Application no: 23/02241/DISC

Location: Land North And Adjoining Home Farm, Banbury Road B4100, Caversfield

Transport Development Control

Objection to discharge of condition 18, Construction Traffic Management Plan.

REVISION DETAILS		
DRAWING No.		
4600-1100-T-011		
DRAWN	APPROVED	DATE
EP	MP	JAN 21
SCALE		REV
AS SHOWN @ A3		F

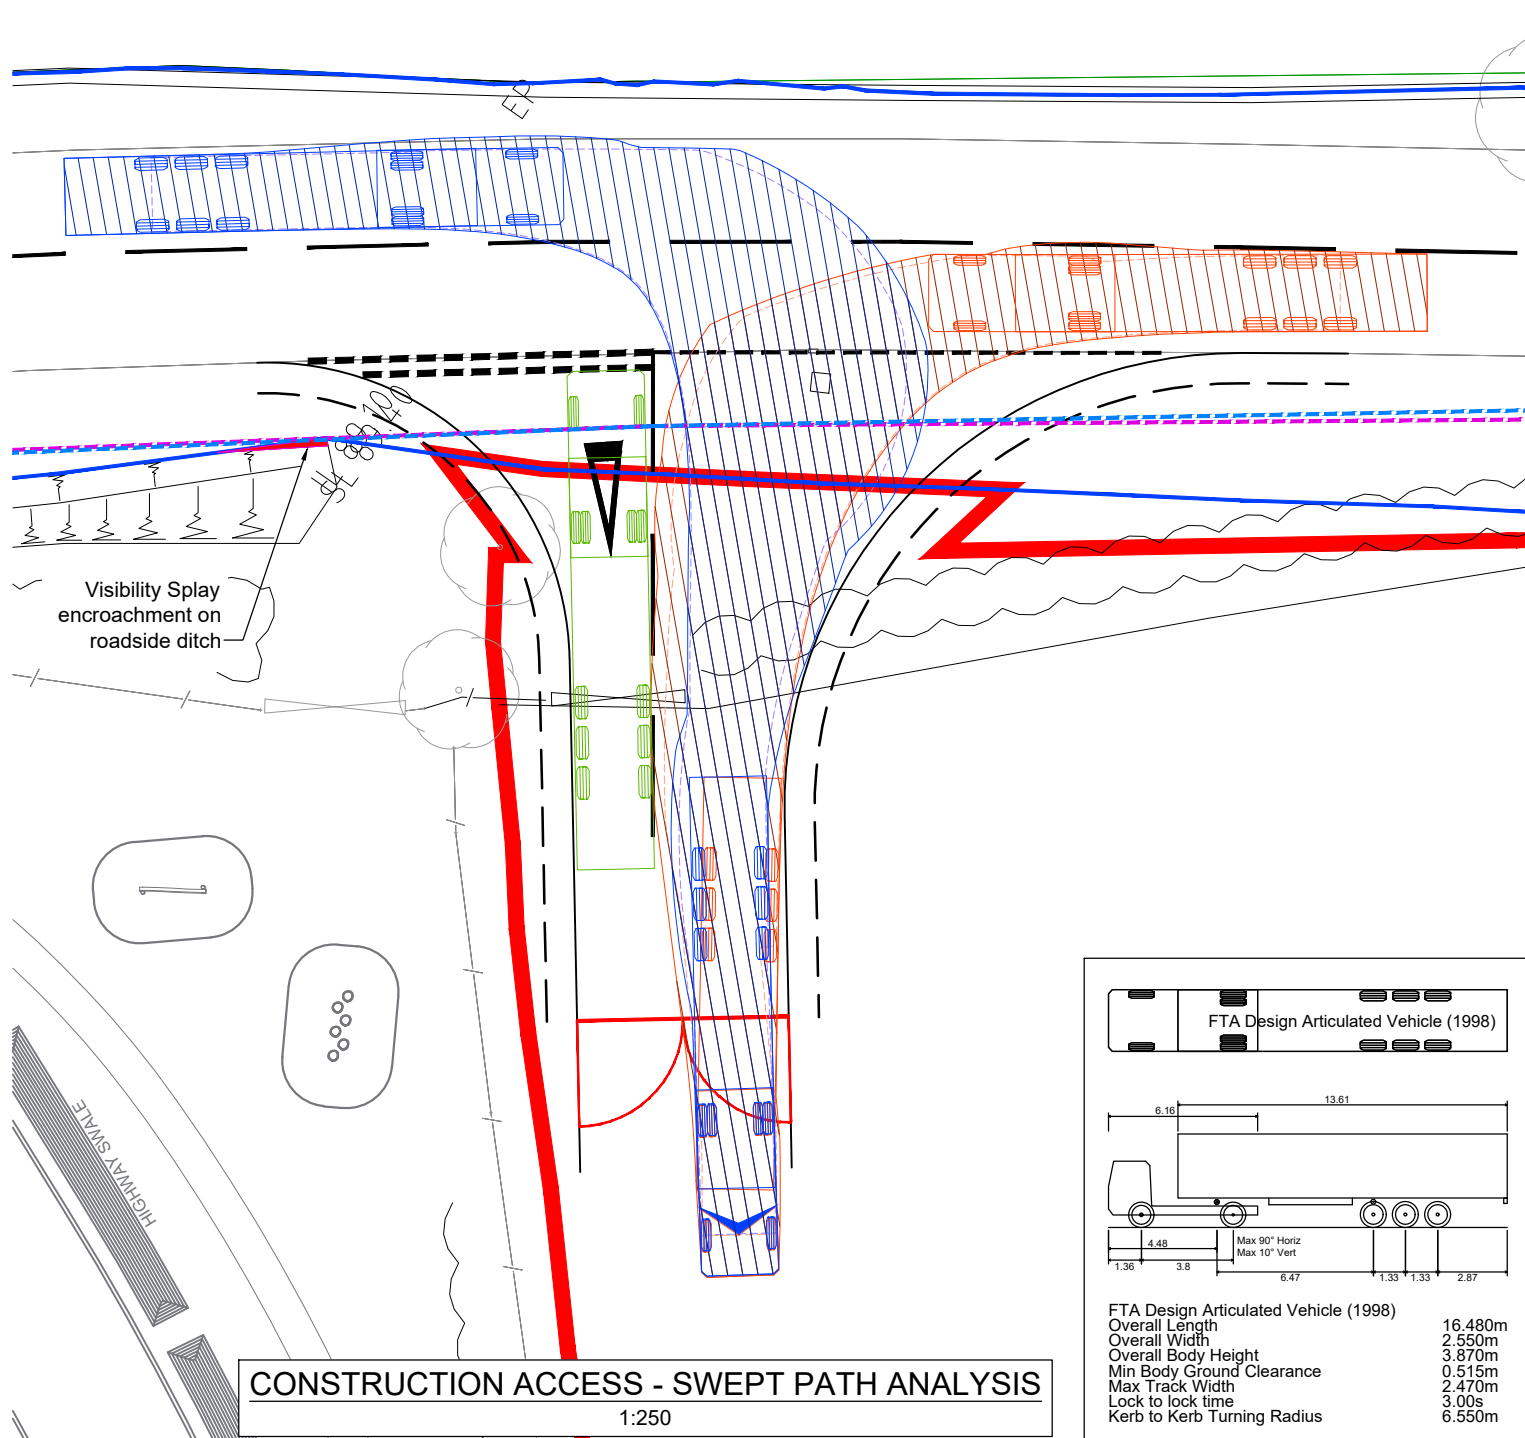
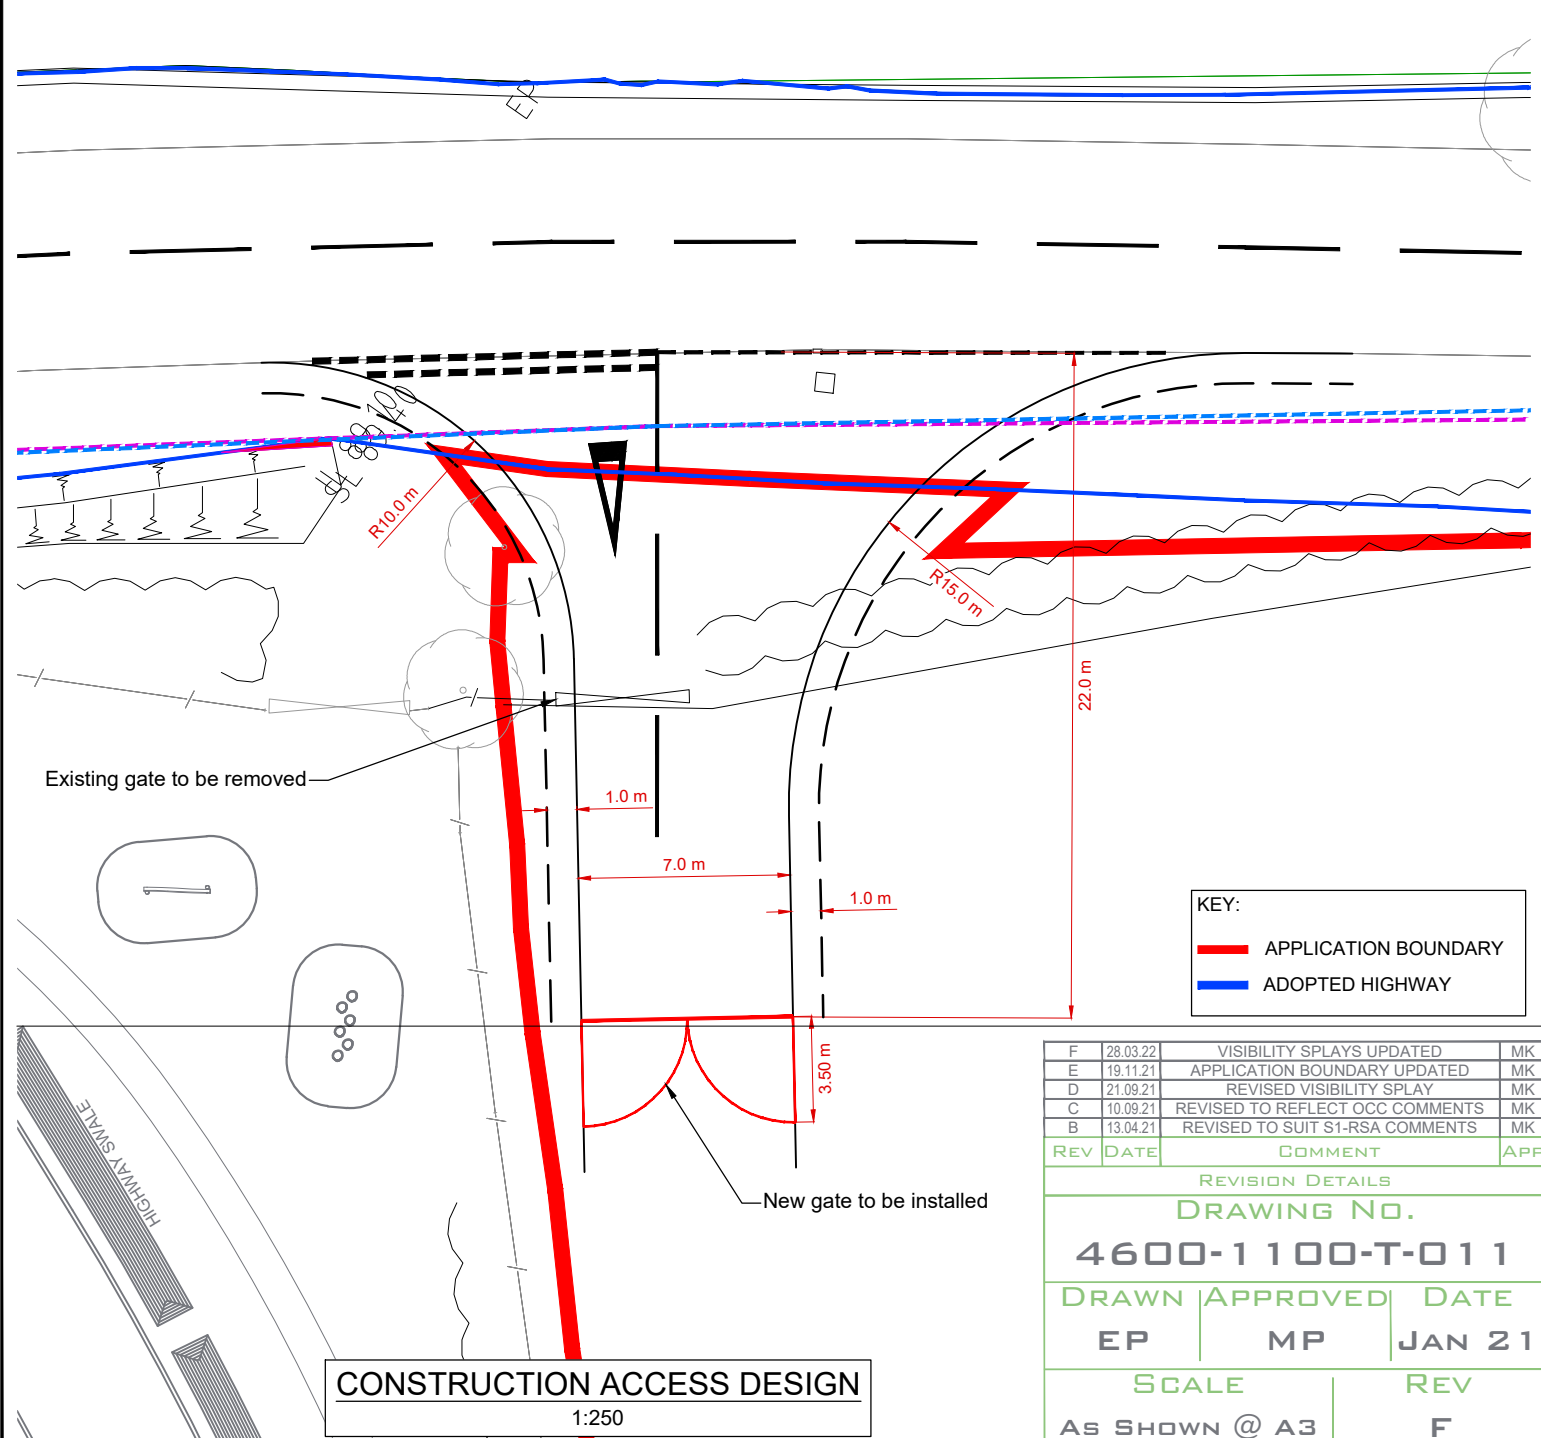
Plans for each of the construction accesses were agreed as part of the planning permission and S278 agreements must be agreed with OCC prior to any works on the highway taking place, with the accesses being constructed prior to any works on site.

B	19.11.21	GSF	APPLICATION BOUNDARY UPDATED
A	14.09.21	GSF	FIRST ISSUE
REV	DATE	BY	COMMENT
REVISION DETAILS			
DRAWING NO.			
4600-1100-T-027			
DRAWN		APPROVED	DATE
GSF		MK	SEP 21
SCALE		REV	
1:1000 @ A3		B

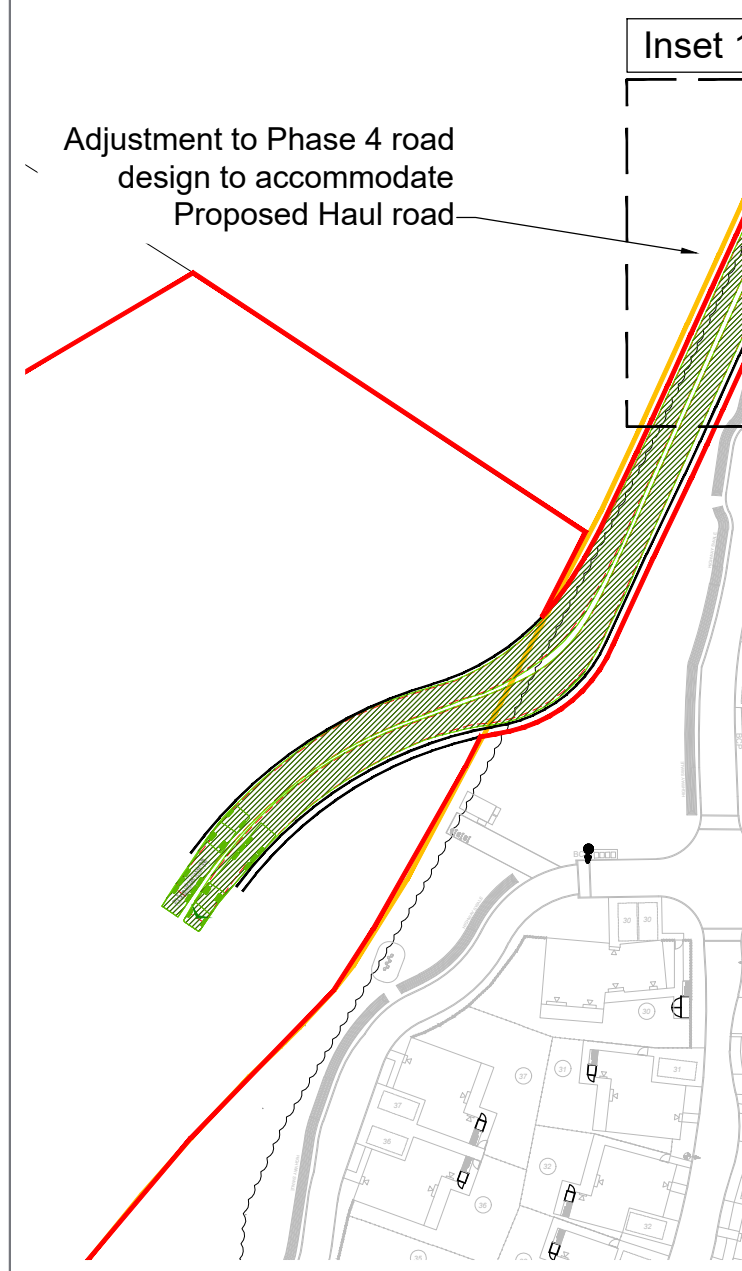
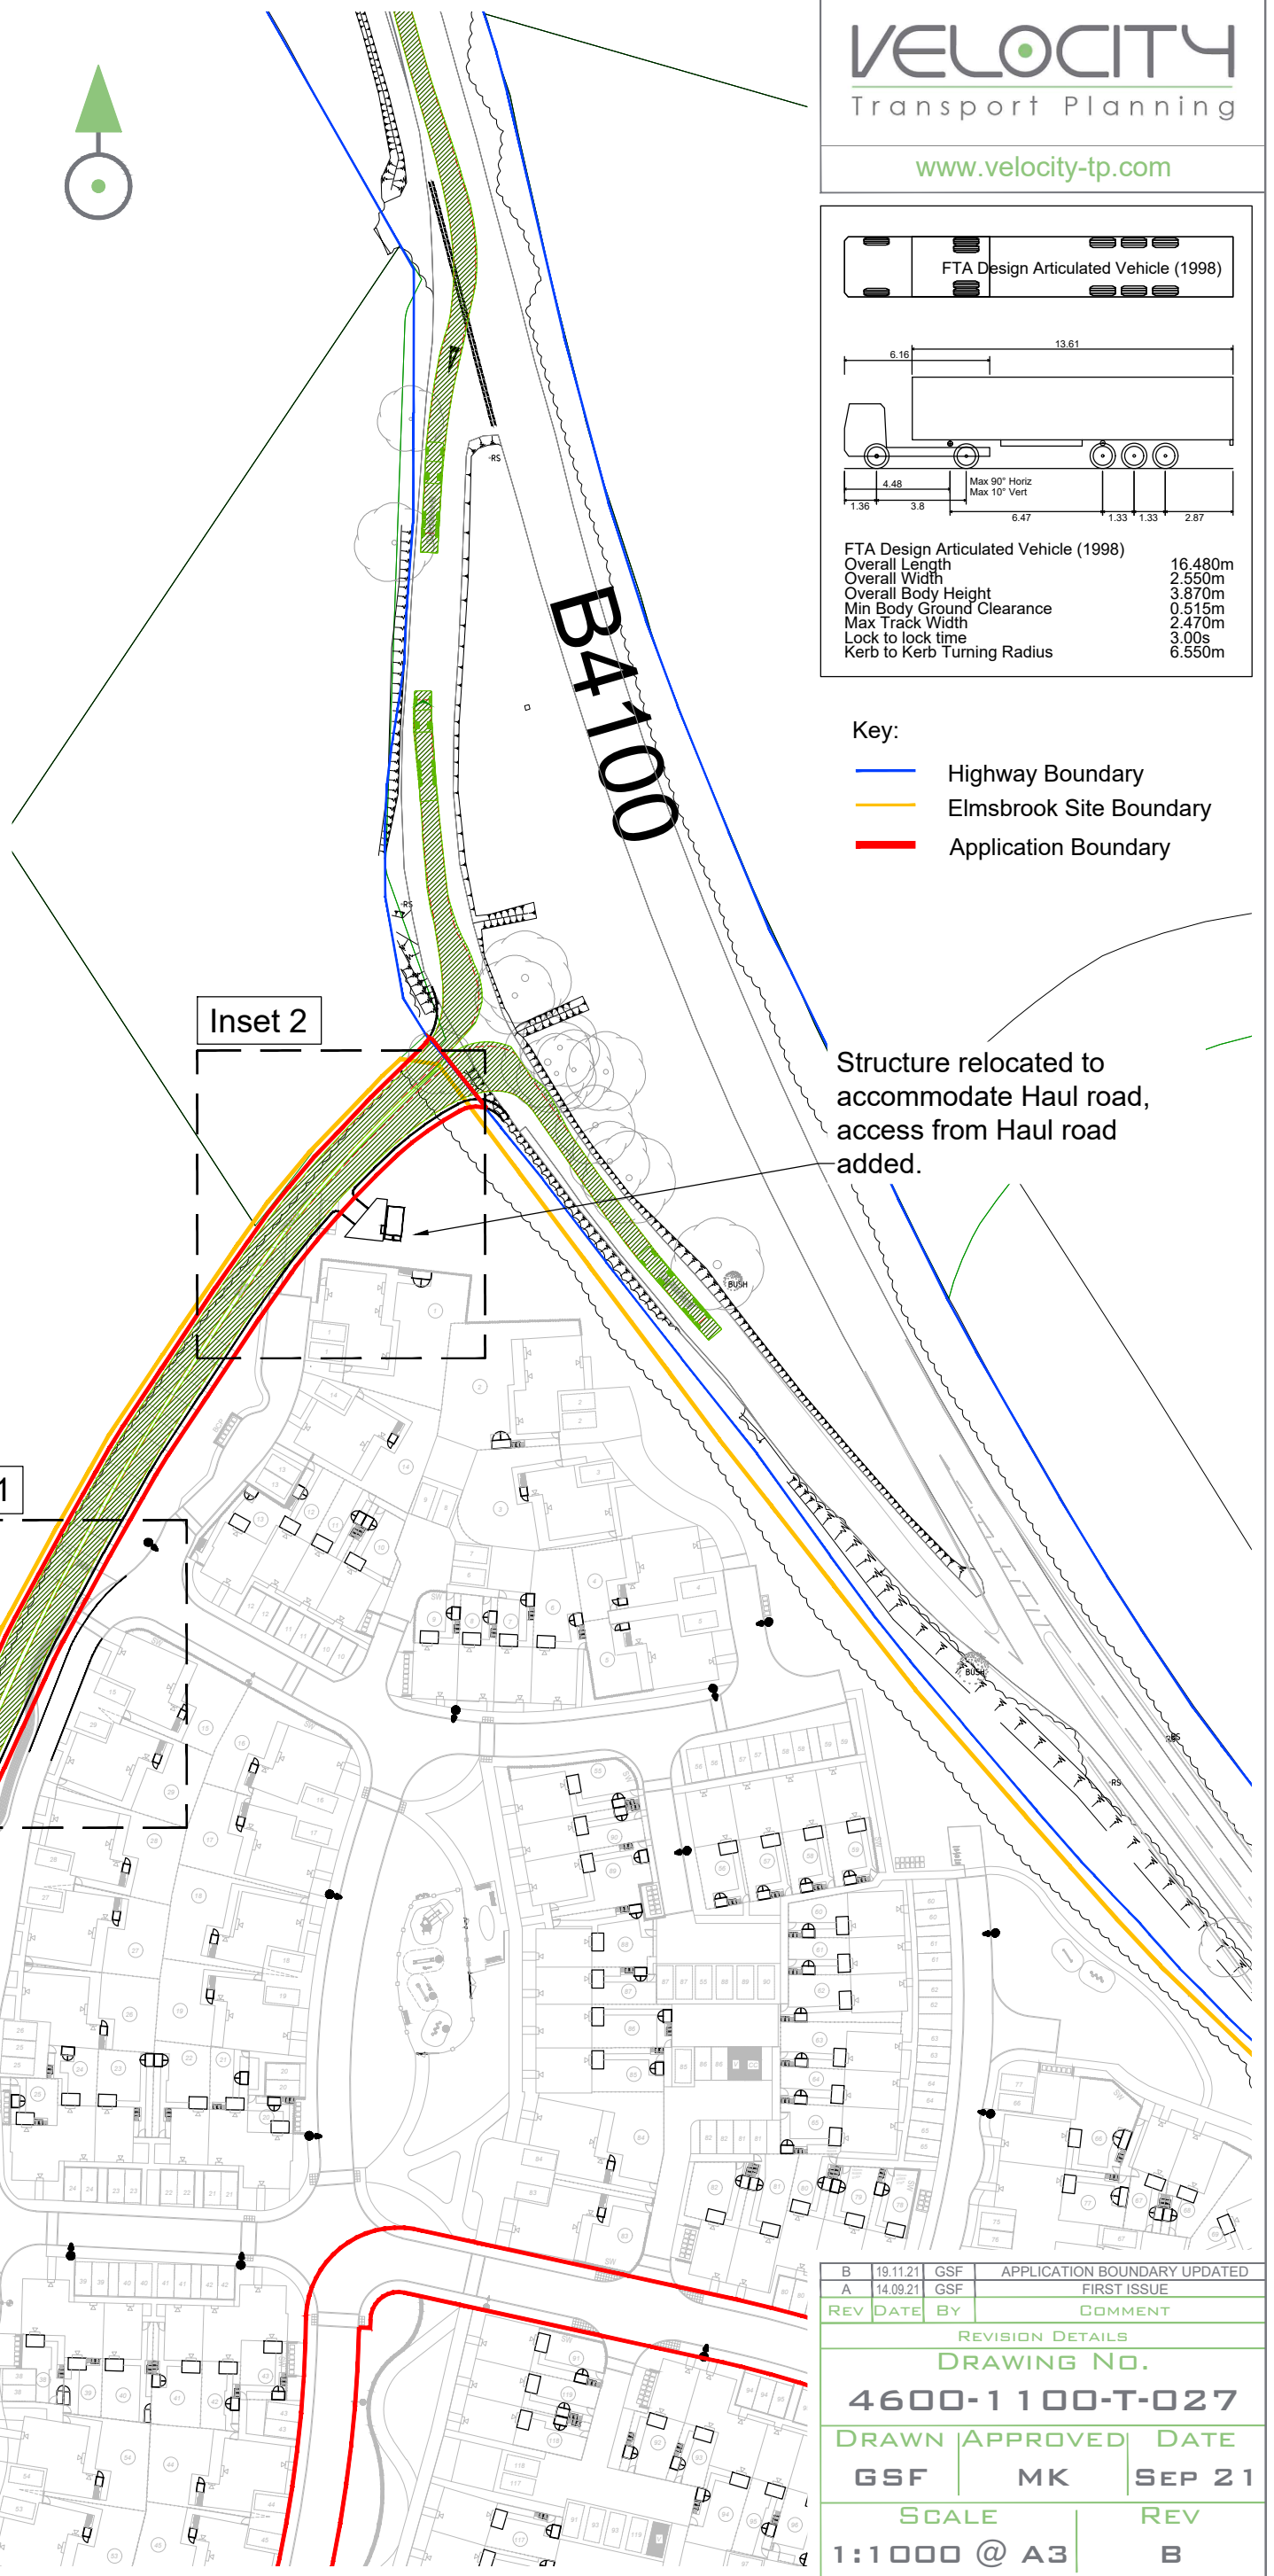
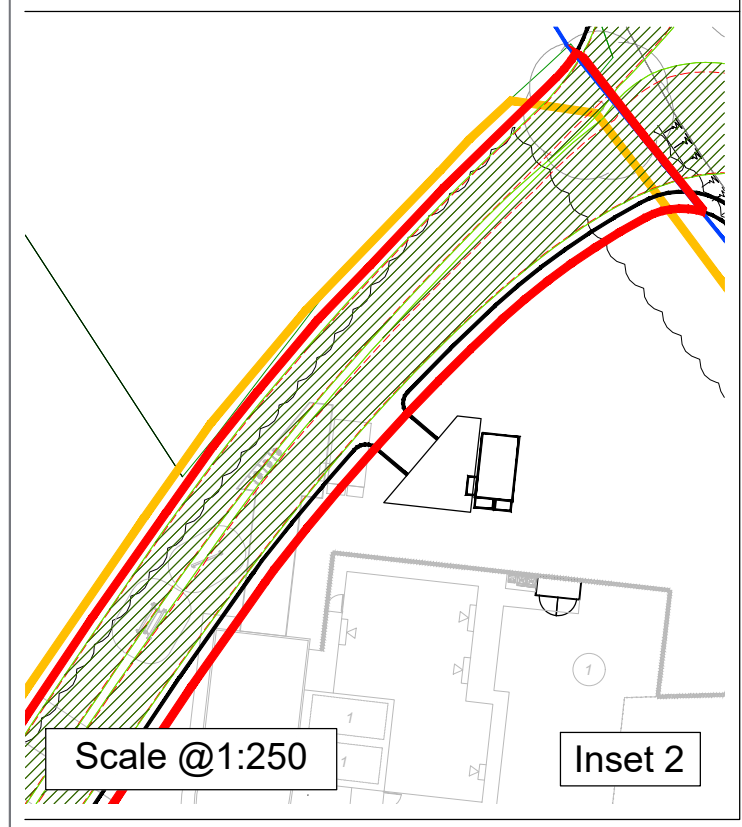
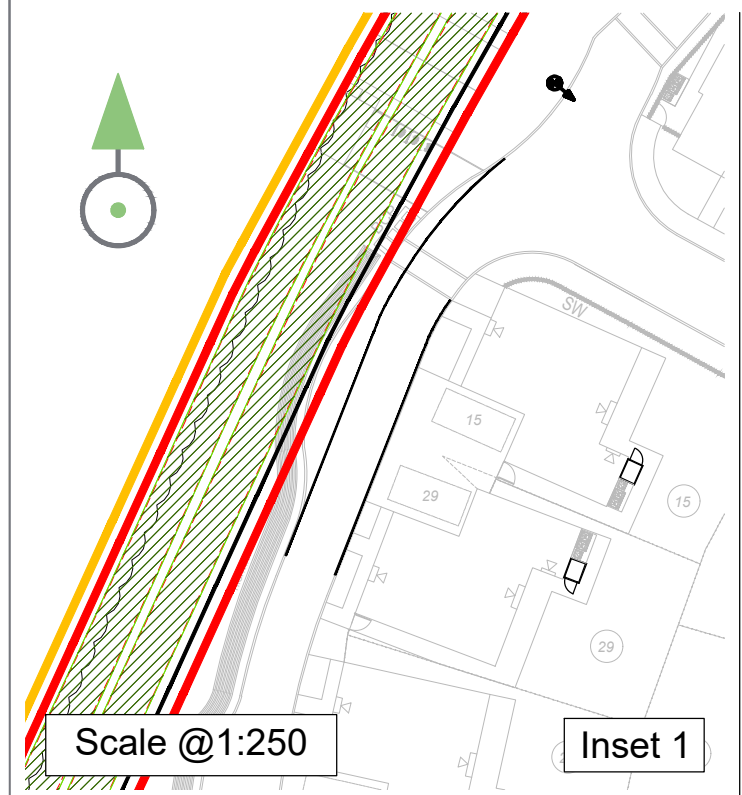
The northern construction access is off a layby which does not have all-movements access. The CTMP should be updated to show how vehicles will enter and leave the layby, and contain specific measures relating to the layby and how the safety and convenience of other layby users (including those accessing the public footpath to Bucknell) will be ensured.
